Engineers Comments Regarding Surface Water Drainage

Application Reference:	AL/35/26/RES	Reviewer Reference:	ADC/ETX4b
Planning Officer:	Amber Willard	Date of Review:	07/08/2026
Site Name:	Land rear of Meadow Way Westergate		
Application Description:	Approval of reserved matters following outline consent AL/178/22/OUT for appearance, landscaping, layout and scale for the construction of 89 No. residential dwellings, together with open space, landscaping and associated infrastructure, with access taken from Meadow Way (resubmission following AL/137/24/RES). This application is in CIL Zone 3 and is CIL Liable as new dwellings.		
Assessment Number:	1

PROPOSED IMPERMEABLE AREAS

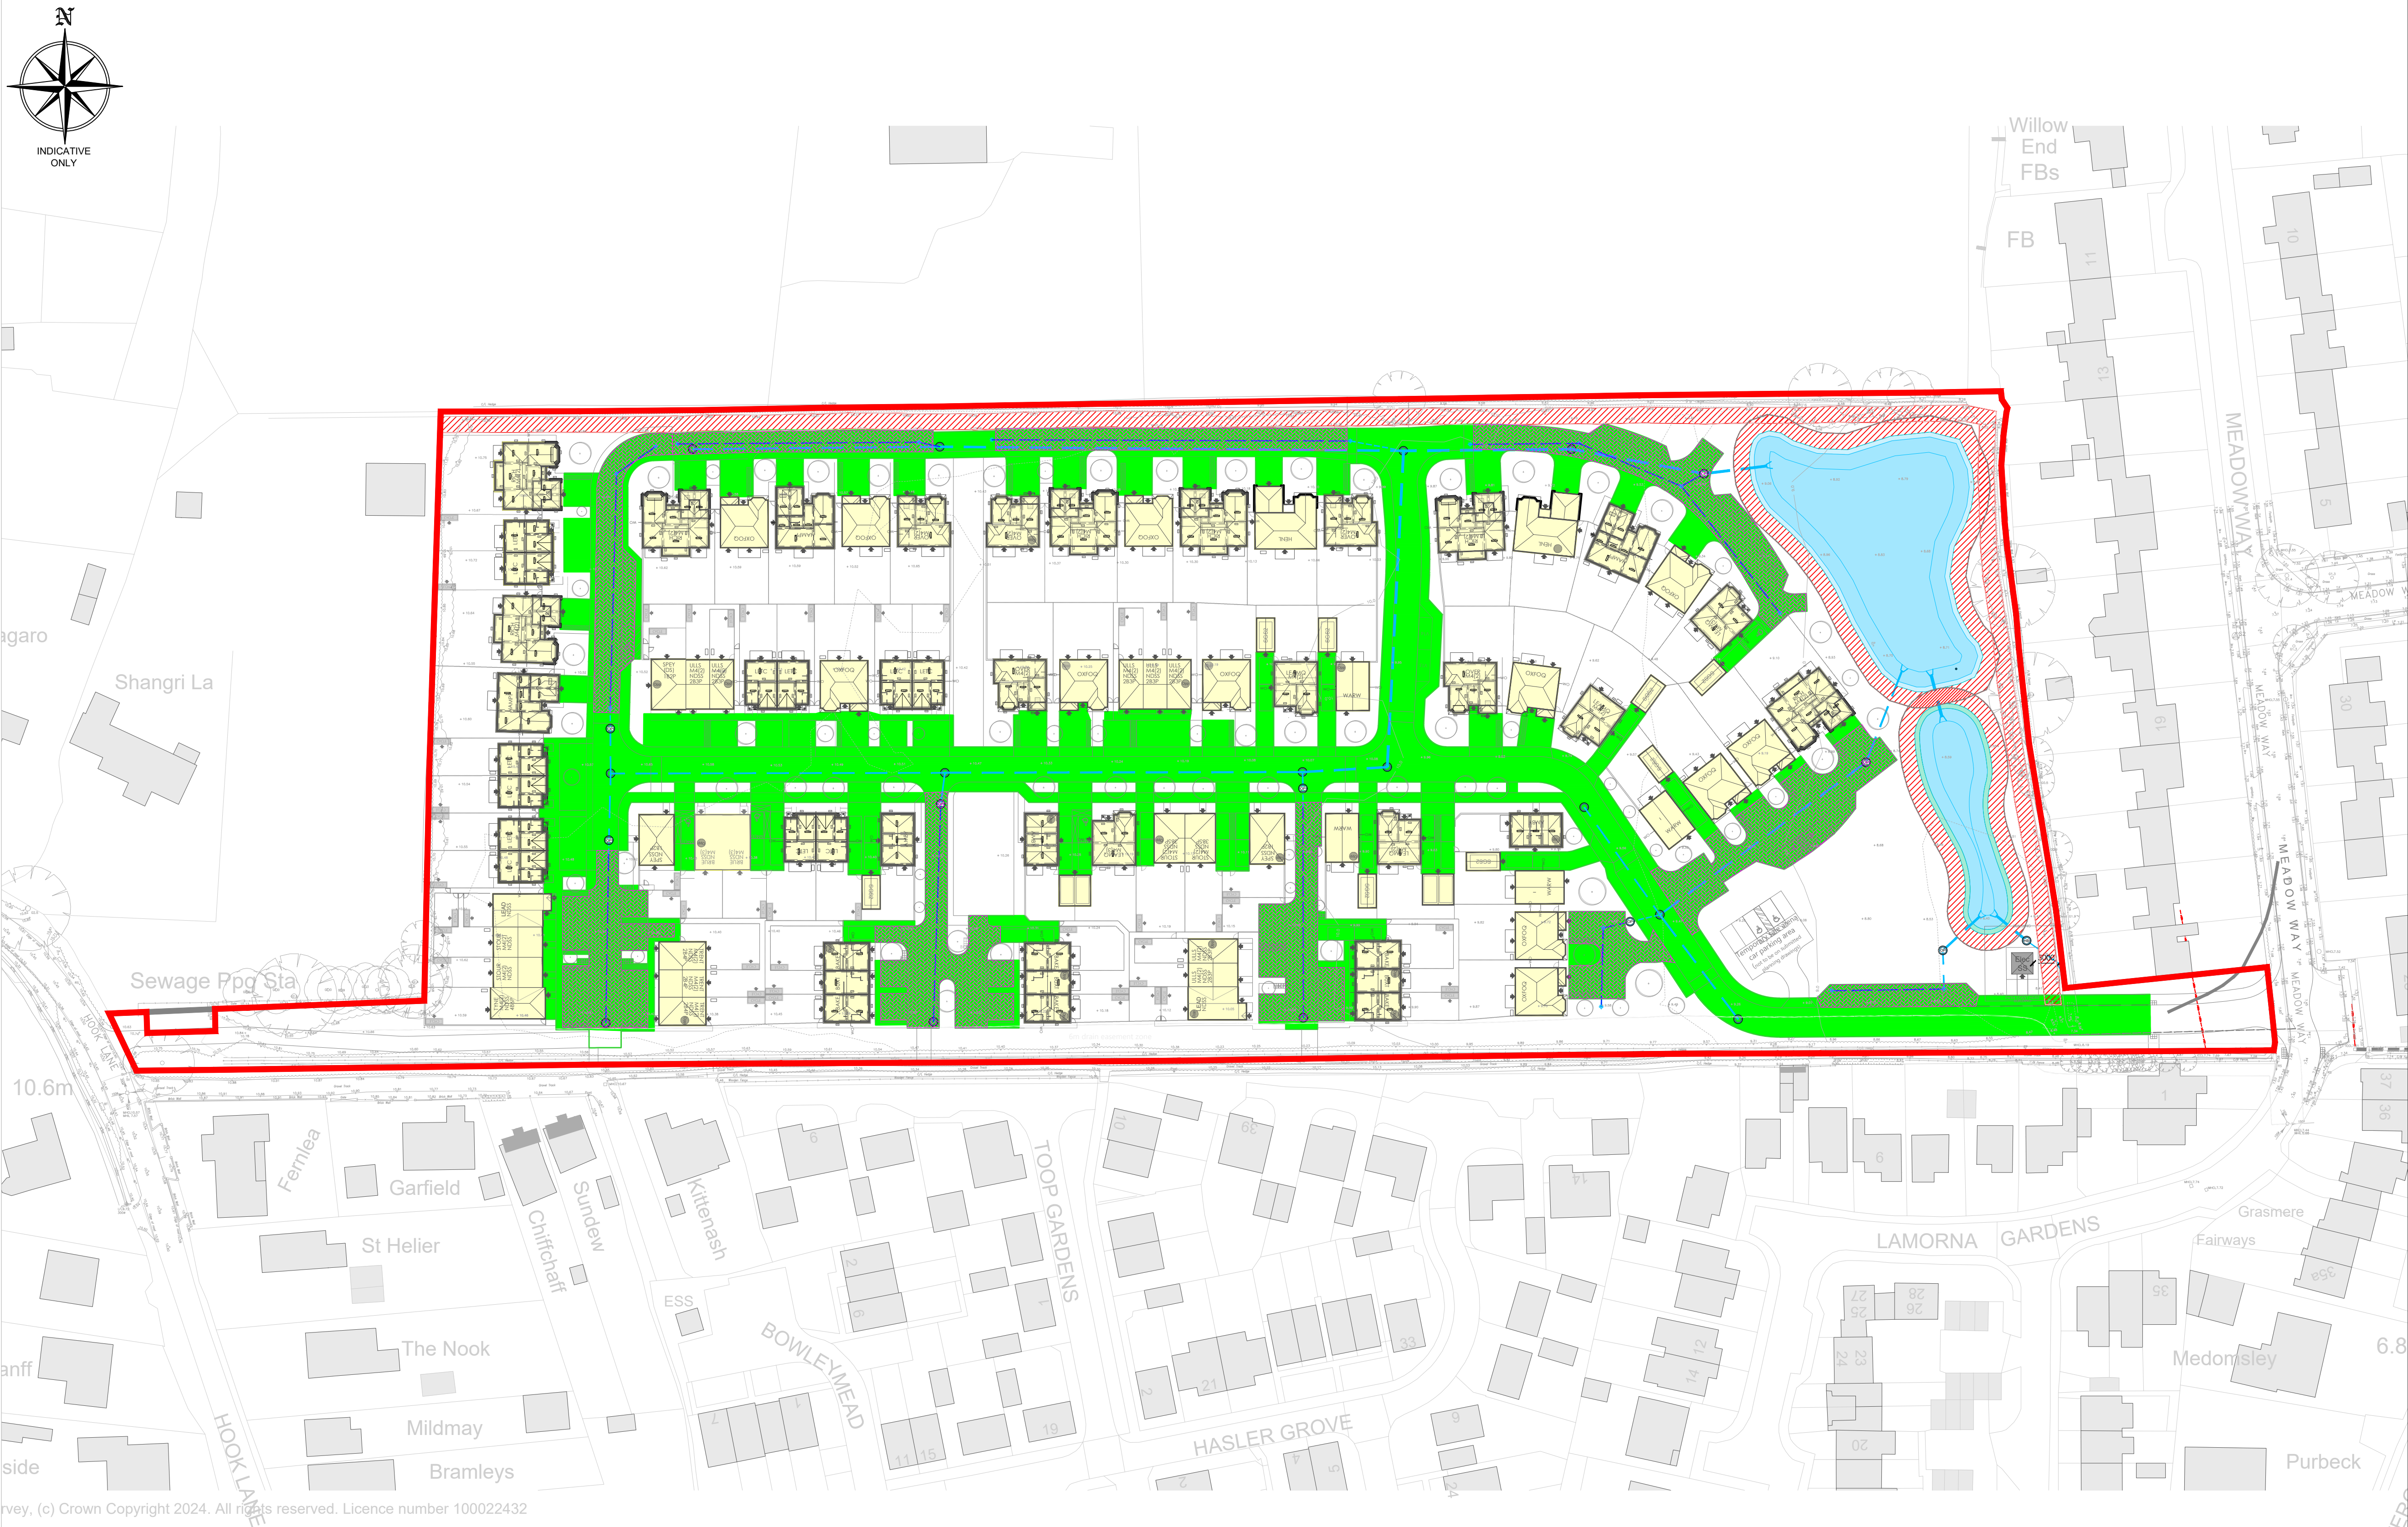
- 3.3. The climate change for the 3.33% AEP event should be 40% (currently set to 35%) this is unlikely to significantly affect the current design but should be corrected for the DOC submission. The modelling does not include the inflows report which demonstrates compliance with regards to volumetric runoff coefficient (CV values), this would warrant an objection to a DOC application or if the drainage condition was linked to the reserved matters as we would need evidence that 100% of the impermeable surfaces are accounted for in the design.

- 3.5. It is unclear how permeable areas, and impermeable areas such as shed and rear garden patios are accounted for in the design. This will be queried when a DOC application is made.
